REQUEST

Current Zoning: O-15 (CD) (Office, Conditional)
Proposed Zoning: RAC(CD) (Regional Activity Center, Conditional)

Approximately 1.53 acres located north of Carnegie Boulevard, east of Coca-Cola Plaza, and south of Rexford Road.

The petition proposes the development of up to 68,000 square feet of office uses, 6,000 square feet of financial institution uses, and 6,000 square feet of restaurant and retail uses the site is currently occupied by an office building.

RZ-1

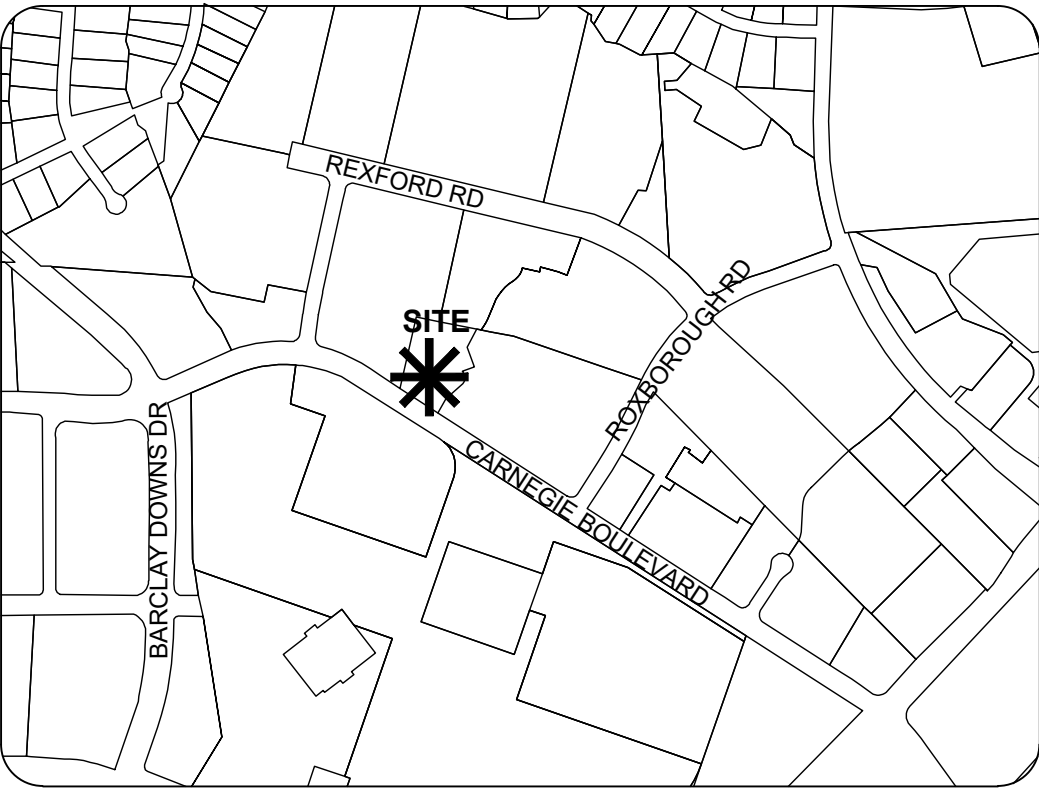
2. ~~Revise site plan and conditional note(s) to commit site access off of Carnegie Boulevard to have a minimum separation of 10' from property line, through the right of way, per the Charlotte Streets Manual. Revise site plan to show the required spacing for drawn site access. Please be mindful when project goes to permitting that the angle of the driveway entering the public right of way must conform with UDO Article 31.~~ **Addressed**

4. **Request:** ~~Revise site plan and conditional note to include mid-block pedestrian crossing at Coca-Cola Plaza. Final location to be determined and approved during permitting. The ped crossing is subject to CDOT approval before installation.~~ **Addressed**

5. ~~Open space language: Add language to notes that when each open space element is utilized, the petitioner shall provide the details/technical notes on the element along with the location of the open space element. Add language to paving materials under open space to provide additional information during the land development process. Add language for shading elements to be more prescriptive in the notes. Open space language: Add prescriptive standards for seating. Open space language: Define and add additional detail for public art.~~ **Addressed**
